Application Ref: 3/2020/0386
Date Inspected: 24/6/20 & Sept 20 by JM
Officer: AD/JM

DELEGATED ITEM FILE REPORT:

Development Description: Proposed new attached triple garage and first floor gable extension to match existing.

Site Address/Location: Old Eaves Hall Waddington Road West Bradford BB7 3JF

Drawing Title: Proposed Layout  
 Client: SPA  
 Date: May 2020  
 Scale: A1  
 Project: Old Eves Hall  
 Address: BB27 2JF  
 Architect: SUDERLAND PEACOCK ARCHITECTS  
 Contact: 01204 252525  
 Email: info@spaa.com  
 Website: www.spaa.com  
 Project No: 6048 - P01  
 Rev: A

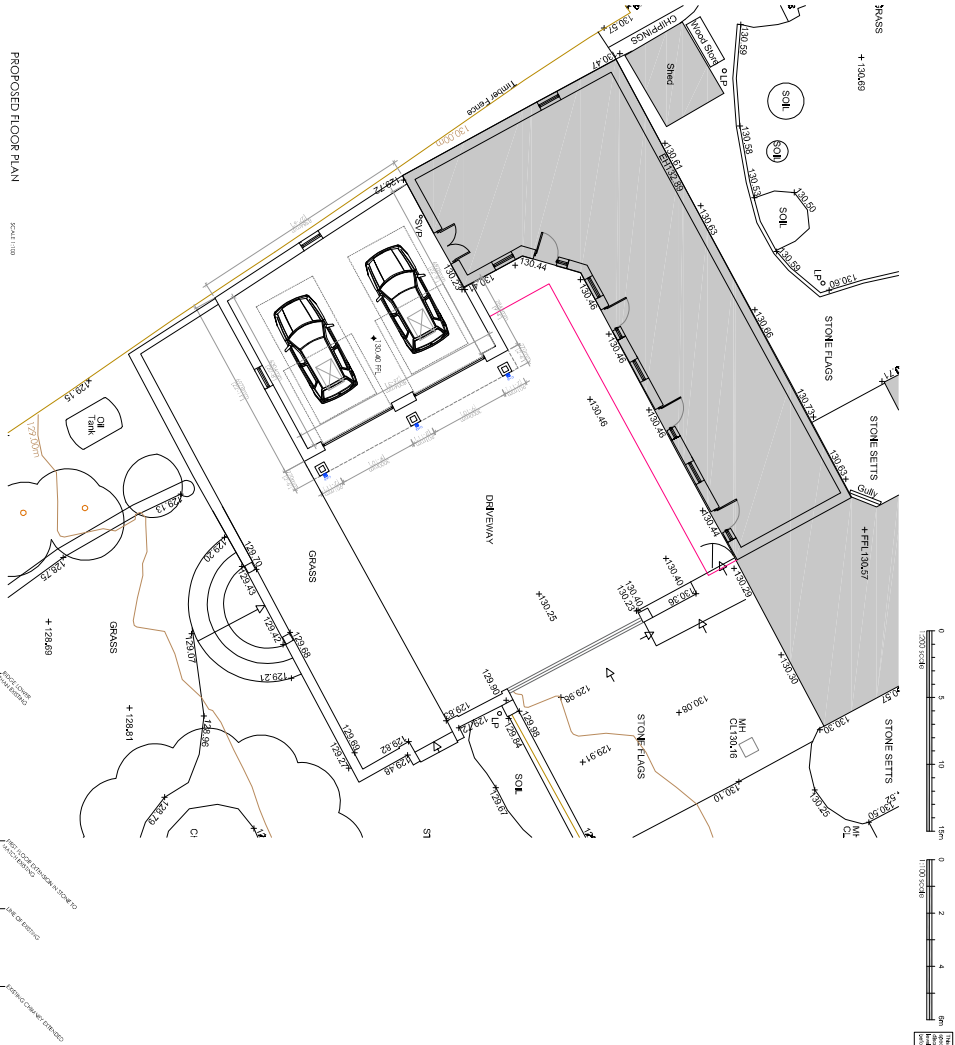
The site has substantial tree screening (when in leaf). However, the proposed garage court is conspicuous and incongruous because of its size, location (in an agricultural paddock; to the front of the house façade) and form (perpendicular to the historic range and its recent extension) and is harmful to the character of the AONB.

The proposed extension is conspicuous and incongruous because of its size, location and form. The front gable extension does not defer to the distinct two-storey single-gable form of the hall which is intrinsic to its historic character. The first floor front elevation triple-light does not respect the existing fenestration pattern. This is harmful to the character of the AONB.

Following a site visit by Head of Service amendments have been secured which result in reducing the garage to a double garage and elevational changes to the alterations to the proposed extensions on the main dwelling house. The extension has been altered to be more subservient and follows a roofline to the existing rather than a gabled extension. Although it will still result in an increase in height and a bulkier appearance it is now considered acceptable by H of S and the amendments no longer result in a harmful impact on the nearby agricultural listed buildings.
